**REQUEST**

Current Zoning: B-2 PED (general business, pedestrian overlay)  
Proposed Zoning: B-2 PED(O) (general business, pedestrian overlay-optional)

Approximately 0.18 acres located on the south side of Central Avenue, east of Pecan Avenue and west of Thomas Avenue.

**STAFF  
RECOMMENDATION**

**RZ-1**

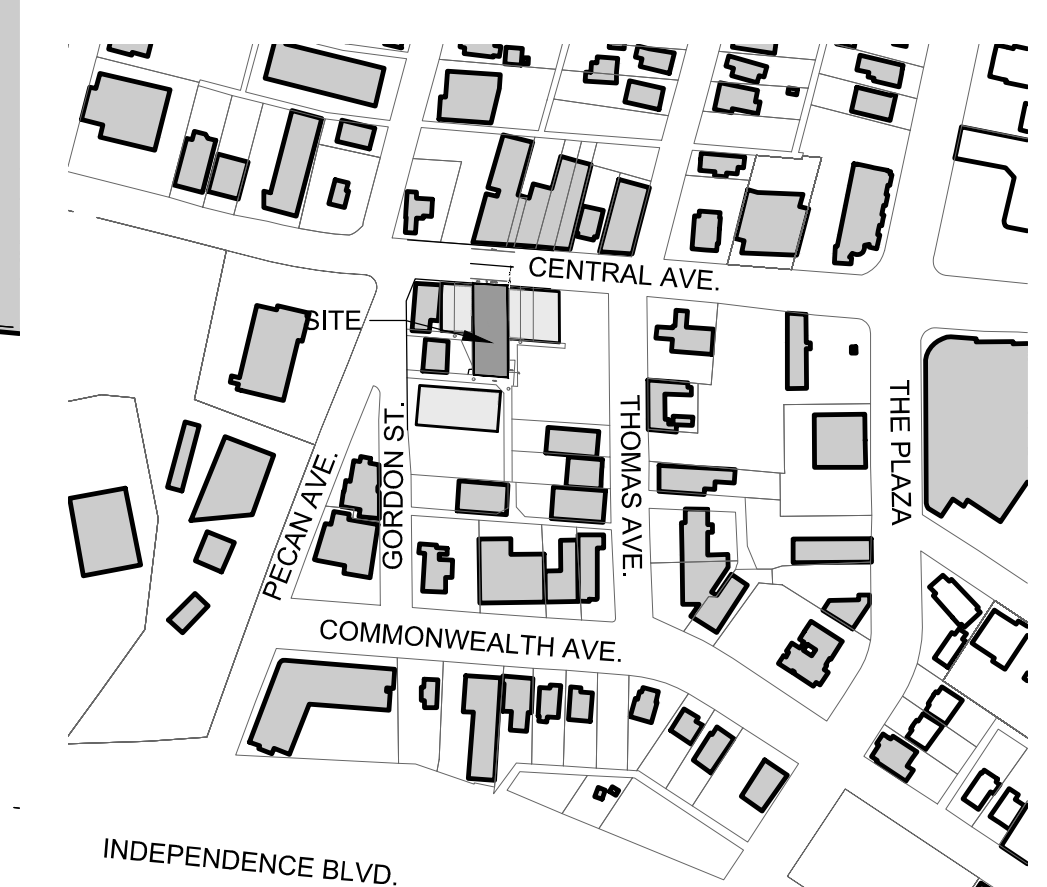
1. ~~Remove Optional Provision 2.f. from the site plan.~~ **Addressed.**
2. ~~Specify type of lighting proposed for alleyway as indicated in Note 7.a.~~ **Addressed.**
3. ~~Clarify type of paving proposed for alleyway.~~ **Addressed.**
4. ~~Amend Note 3.c. and other applicable language on site plan to provide a clear commitment to preservation of the existing building.~~ **Addressed.**

5. ~~Correct misspellings on site plan under *Maximum Gross Square Feet of Development*.~~ **Addressed.**
